From: Pagham Parish Council [REDACTED]
Sent: 30 September 2015 10:13
To: Planning.Responses
Subject: Pagham Parish Responses

P/86/15/PL 11 Abbotsbury Pagham PO21 4RX - 1 No. 2 bedroom semi-detached bungalow

PROJECT	11 Abbotsbury Road	DATE	23 June 2015
TITLE	Proposed Plans and Elevations	DRG NO	IBA/433/02
SCALE	1 : 100	REVISIONS	A

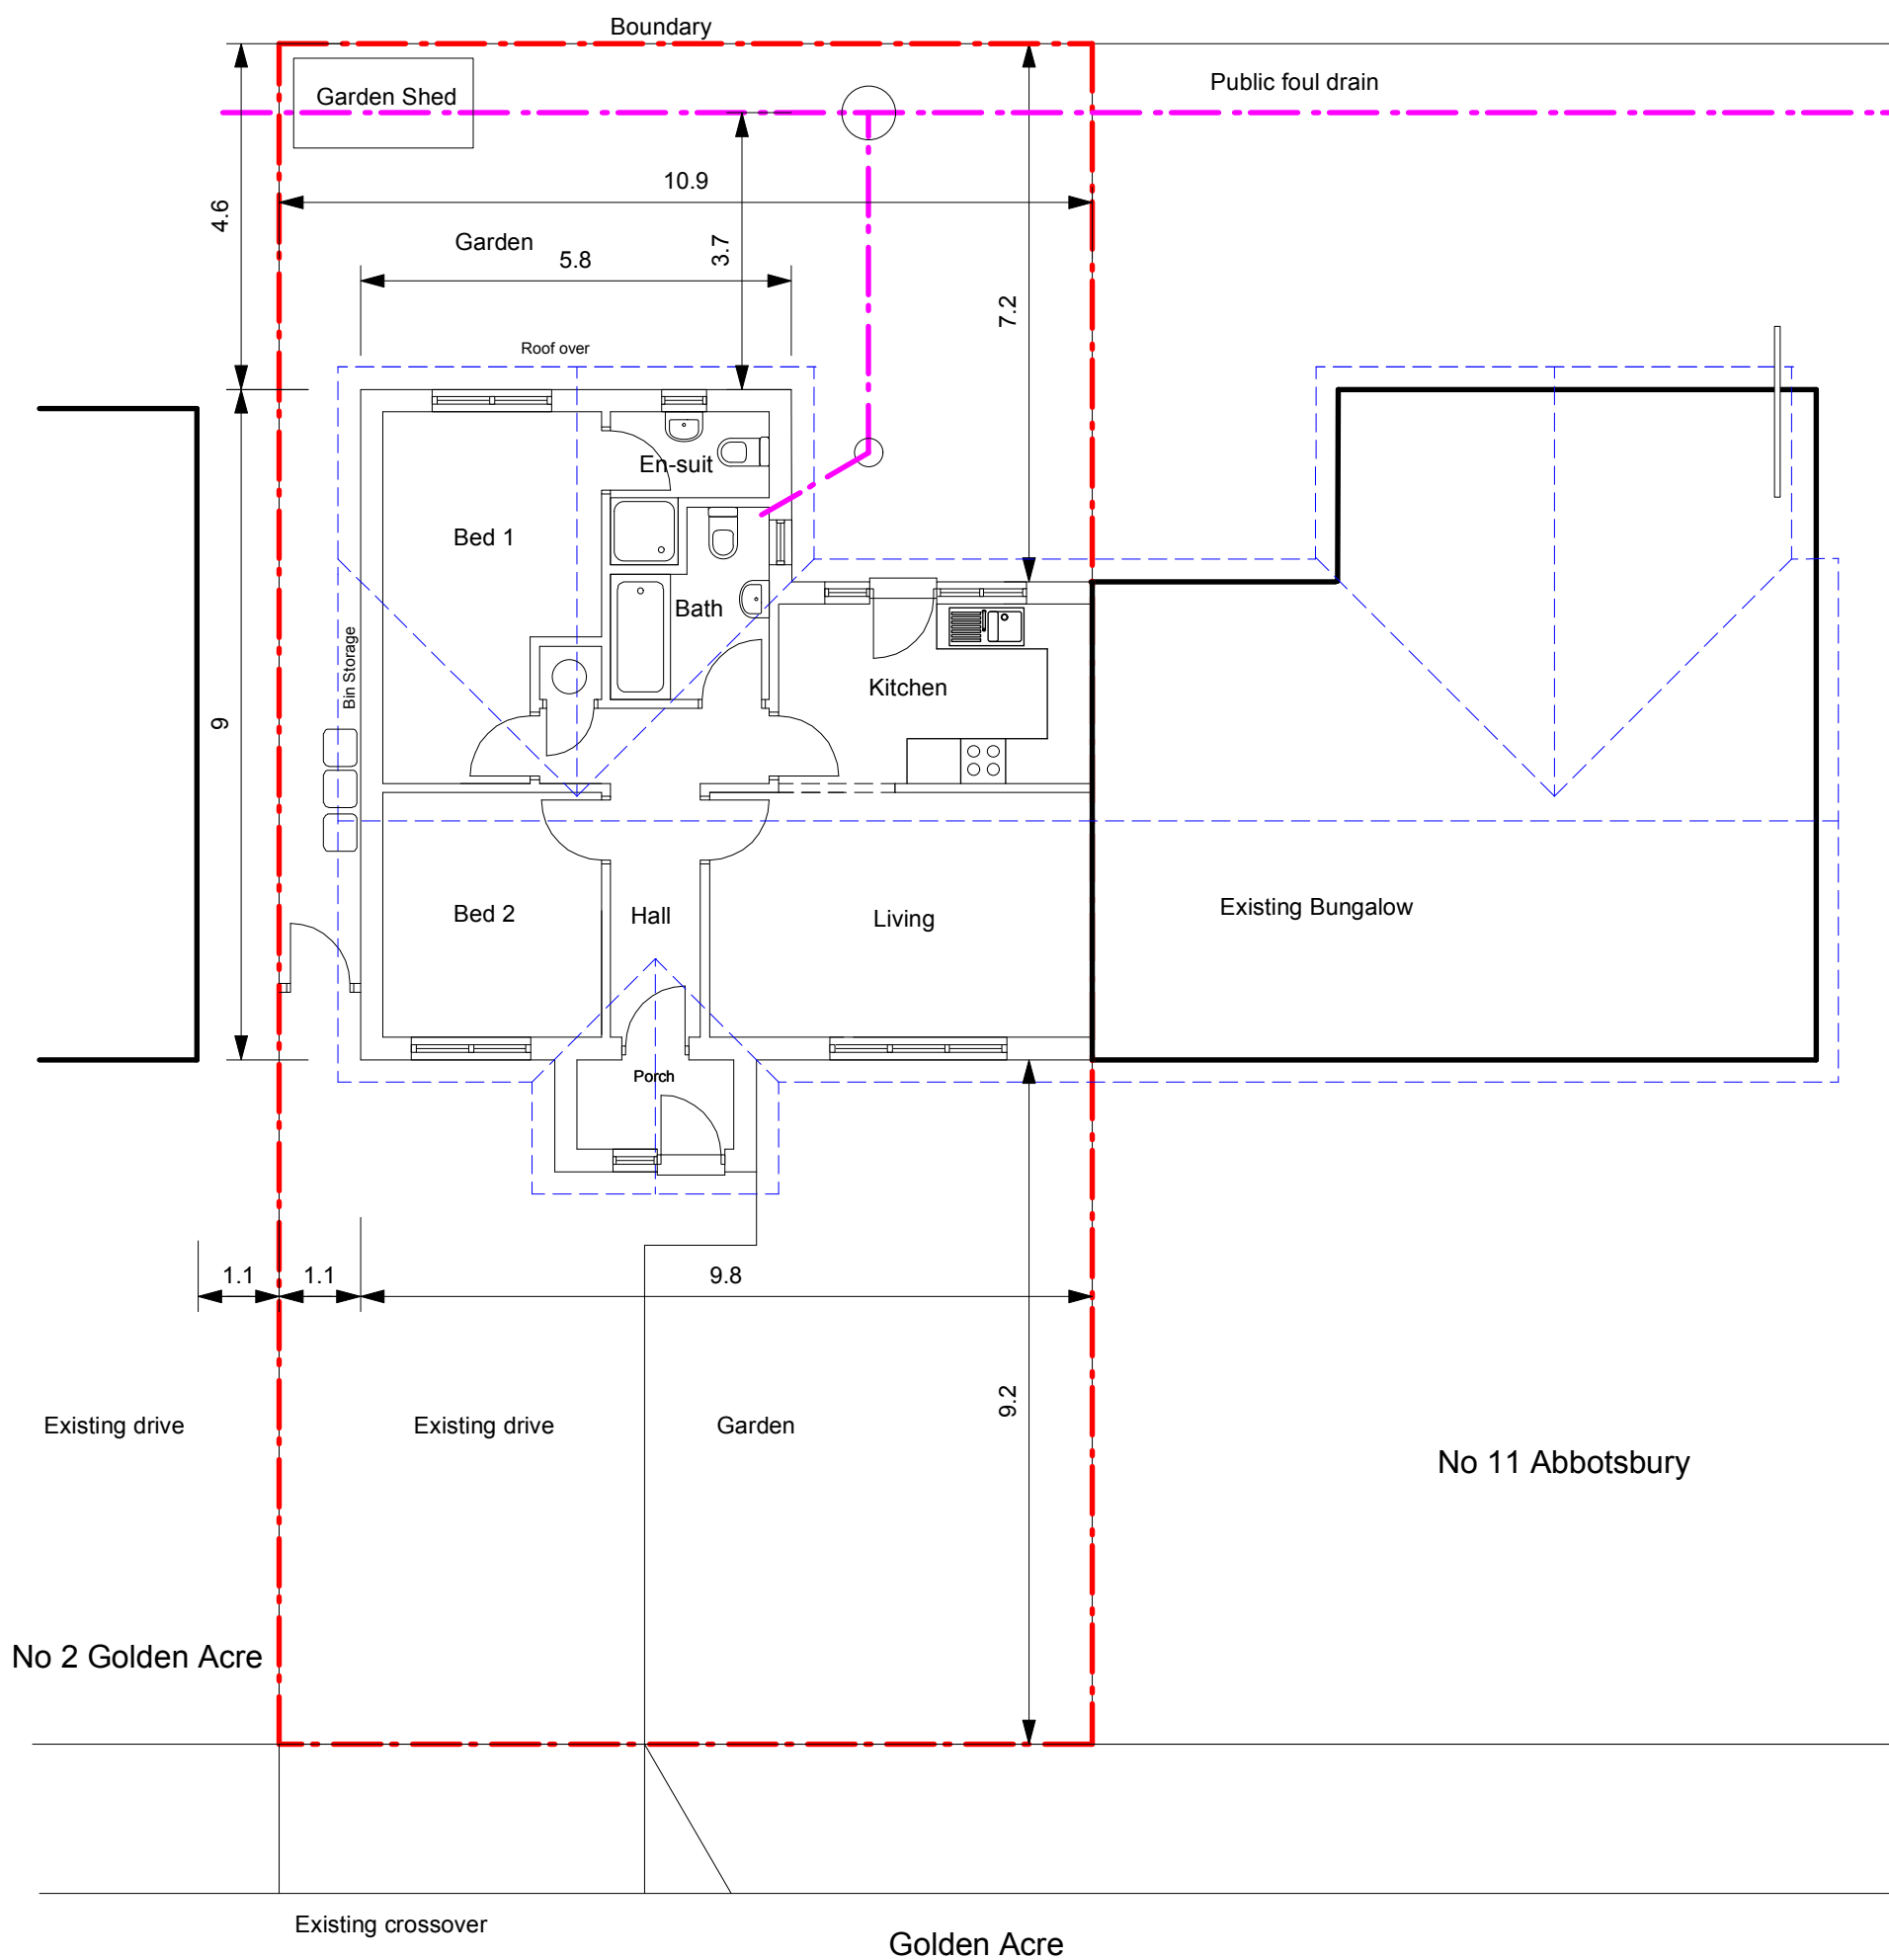
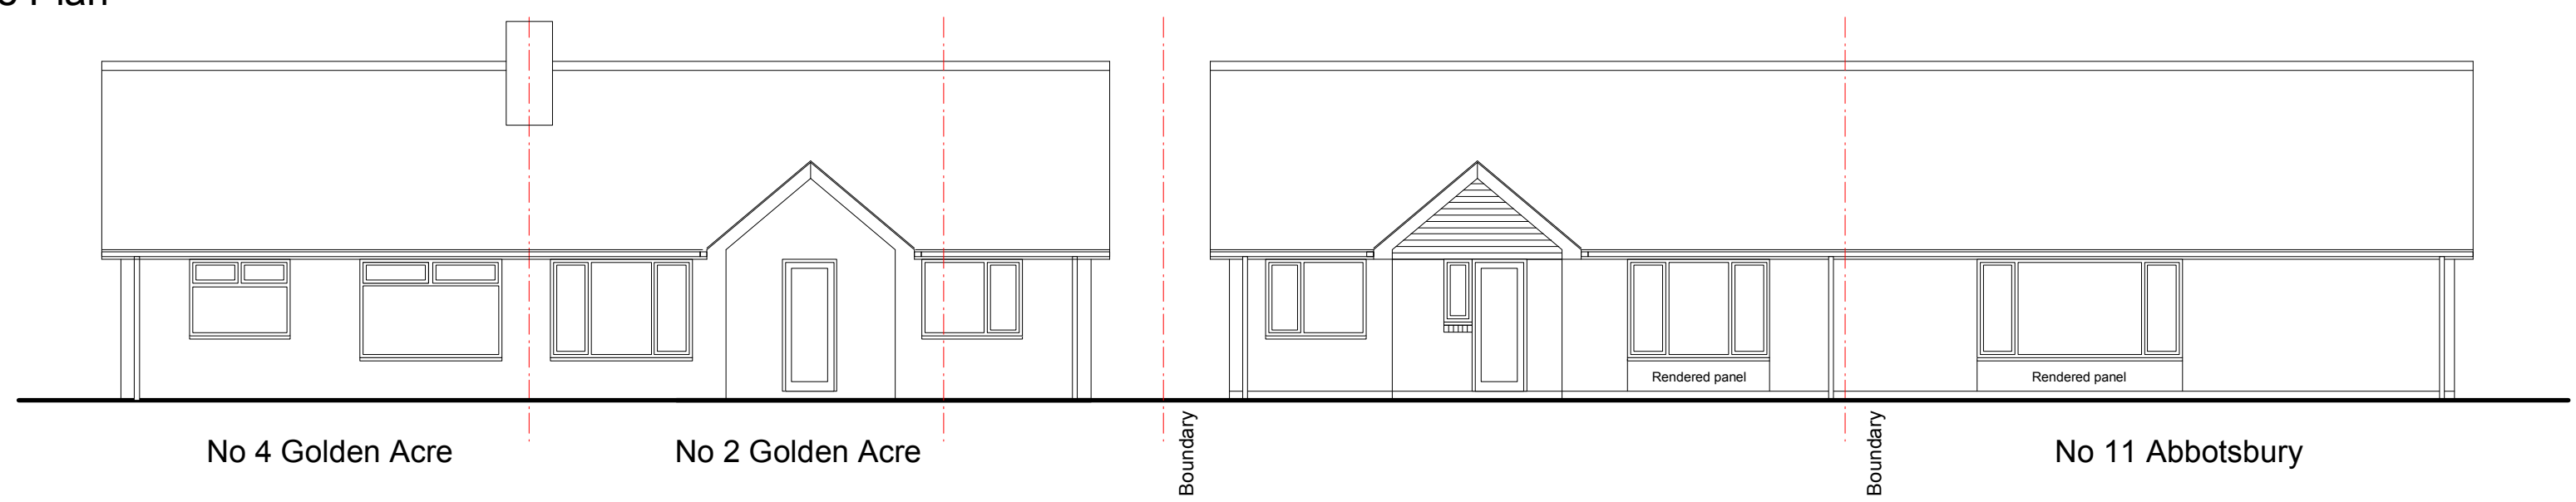
AGREED RESPONSE: Pagham Parish Council objects to this application as it constitutes an over development of the site resulting in reduced rear amenity garden space for both properties and is an unneighbourly development. It was agreed that Cllr Radmall would draft a full response to be agreed by email. Cllr Hall wished to abstain to this proposal.
